From: brad hanson <[REDACTED]>
Sent: 22 September 2021 11:26
To: Simon Davis
Cc: [REDACTED]
Subject: Re: CM/52/21/DOC
Attachments: PL2 rev C.pdf

Ok I understand the position re the Laurels. It is a shame that they will be hidden but I appreciate that you can't lock them down and also that the condition requires boundary treatments not landscaping.

N DISTRICT COUNCIL CM/52/21/DOC

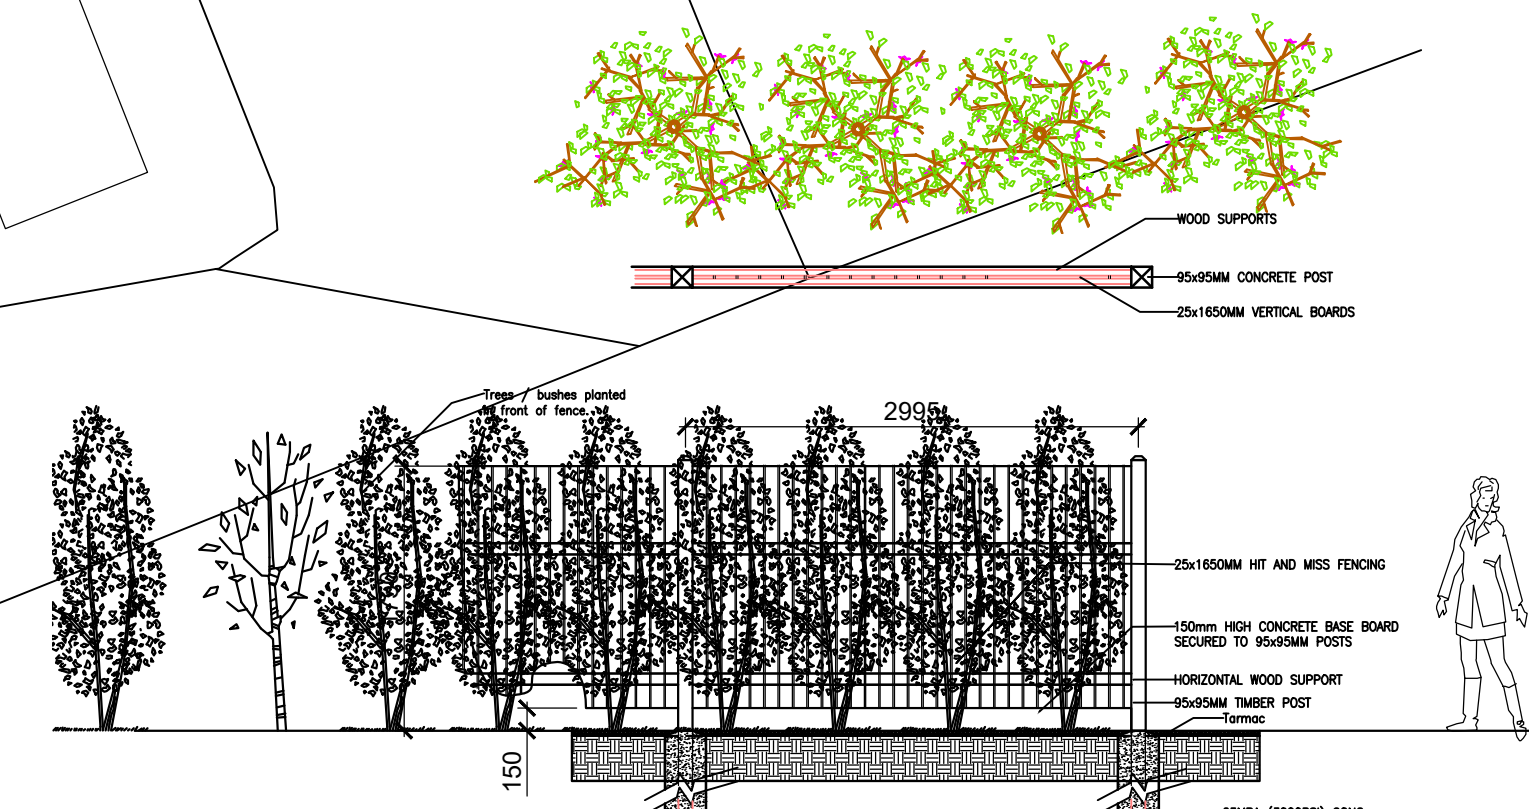
Can you add a note to the plan to say the western green is existing planting and the southern green is new Laurel plants.

Can you clarify what the greenery (behind the respective fence lines) is on the plan. I suggested that you retain the laurels on the southern boundary to the front of the fence (i.e. your side). Is the green on the western existing? Please clarify on the plan and resubmit. I believe we are nearly there on this.

The green planters on the Western are currently there as that's the neighbours garden.

For visual on the southern side for the neighbour were suggesting that we plant laurels which will grow over time so that they visually see those rather than fencing.

With regards to the laurels on carpark side we would rather not have to purchase more and replant due to the risk of them being stolen again which has recently cost us £1000 already
